From: Dawn Appleton [REDACTED]
Sent: 14 September 2017 15:06
To: Simon Davis
Subject: RE: Land at Ashurst Close, Bersted

North Elevation

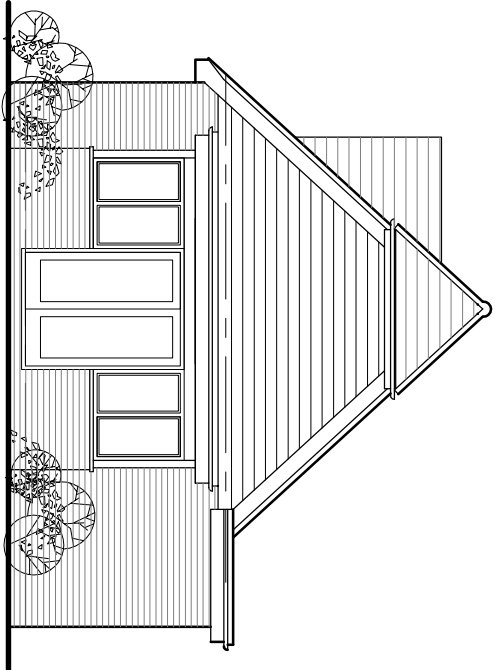
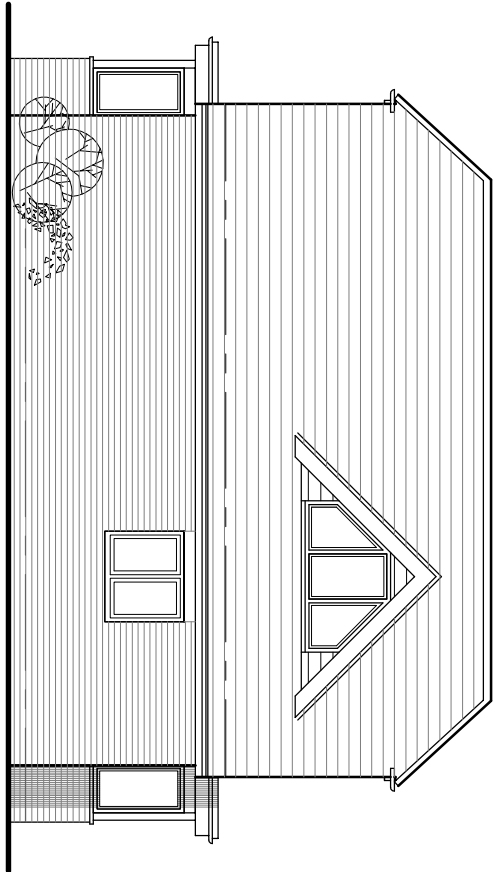
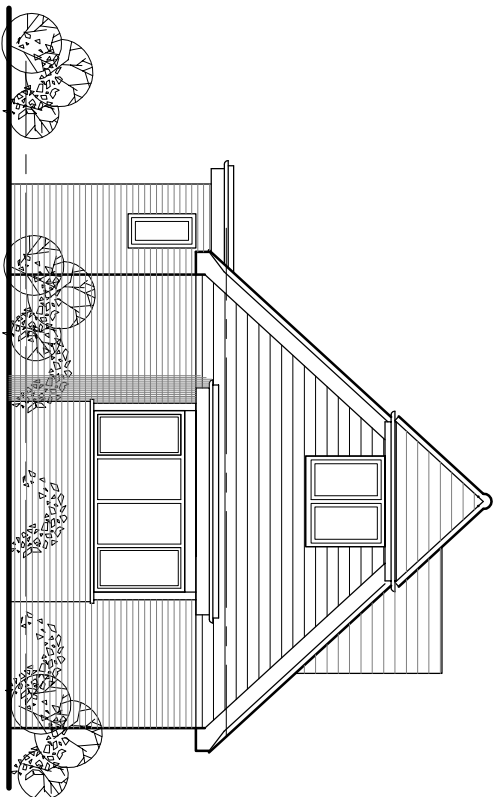
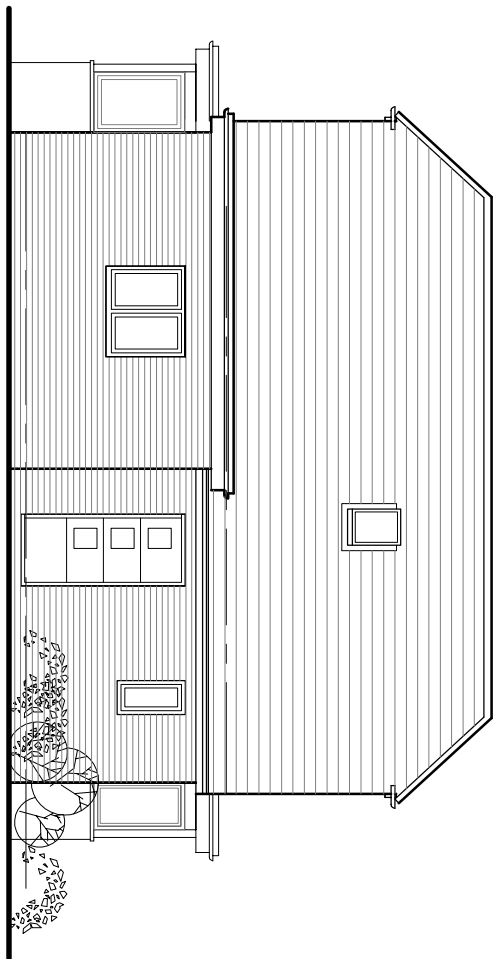
Thanks for these. Just one query, you are showing a first floor window in the North elevation where there was not one previously and this window appears to be within a wardrobe. I assume this isn't right?

You are quite right. Please find amended plan attached.
